MECKLENBURG COUNTY
Park and Recreation Department

MEMORANDUM

DATE: May 19, 2023

RE: Rezoning Petition #2022-200
PID# 04711207

SCHEMATIC SITE PLAN

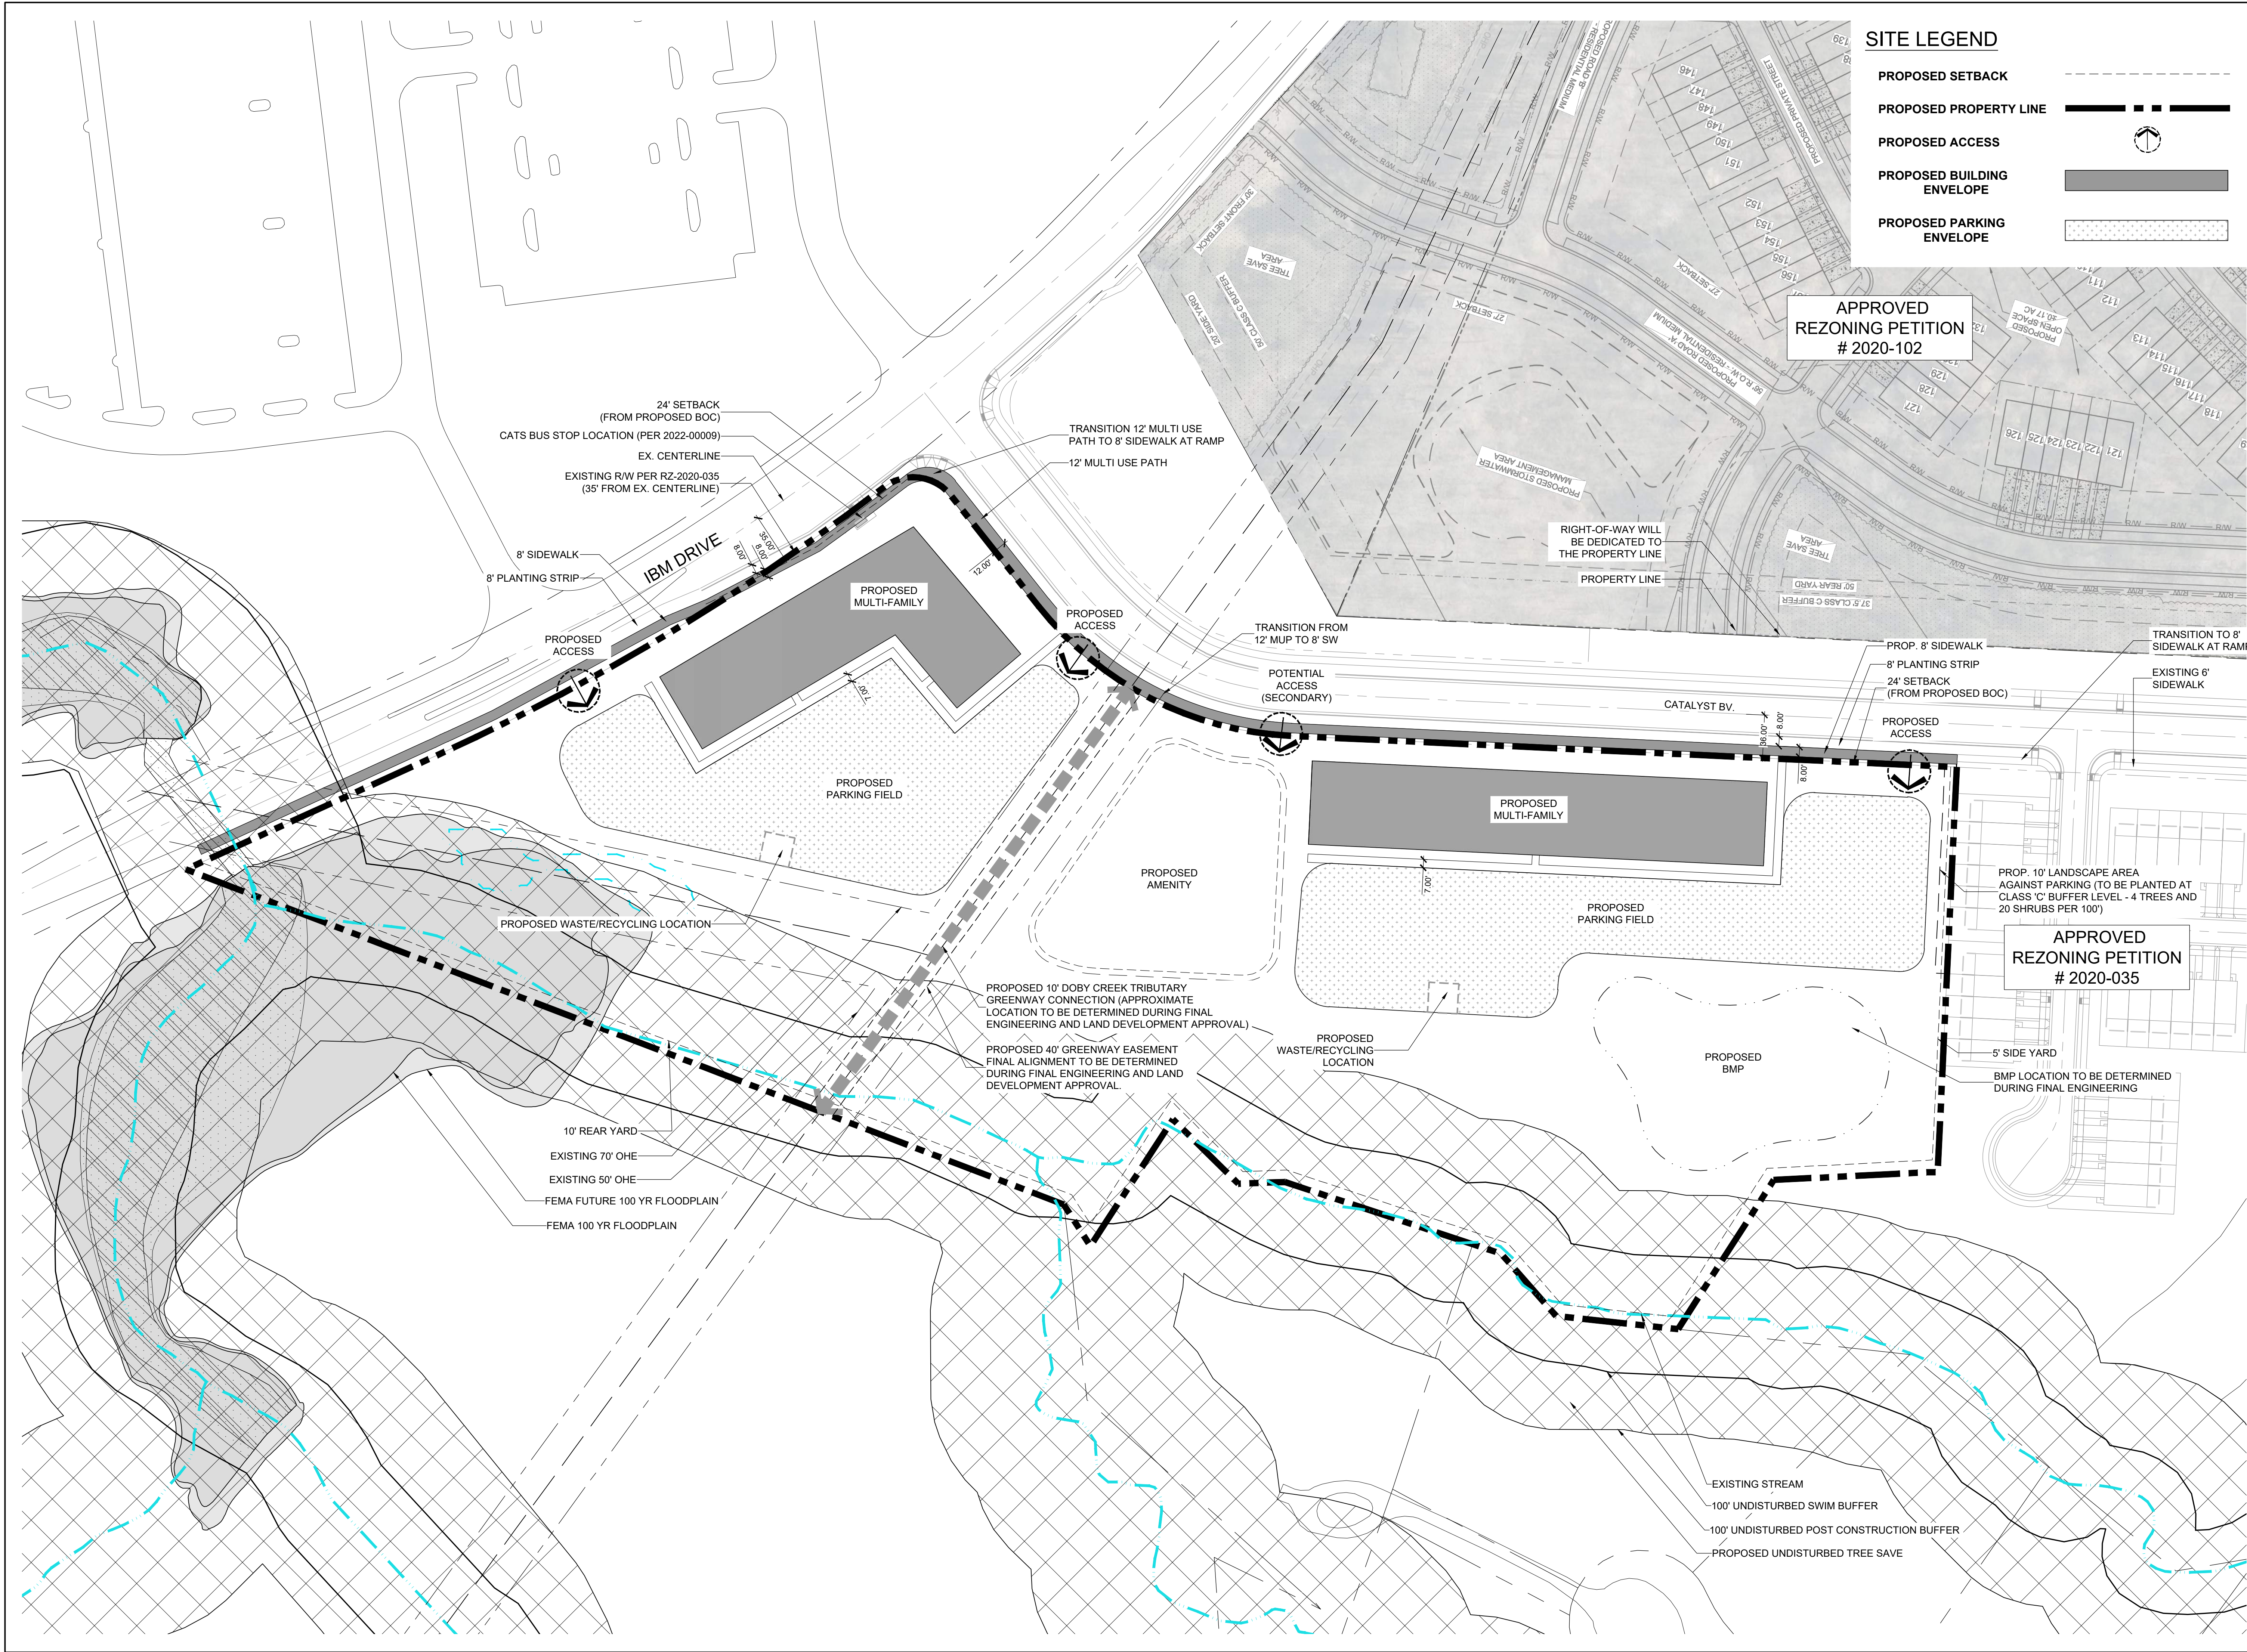
Plans currently show that the developer will build a 10' trail and provide a 20' easement between the Catalyst Blvd multi-use path and Mecklenburg County Property. Mecklenburg County's preference is for the developer to provide a 60' easement along this corridor for Mecklenburg County to construct the trail in the future. If the developer still wants to construct the trail and dedicate the trail to Mecklenburg County, the trail should be constructed to County standards at 12' width with a minimum permanent easement of 22' along the constructed trail.
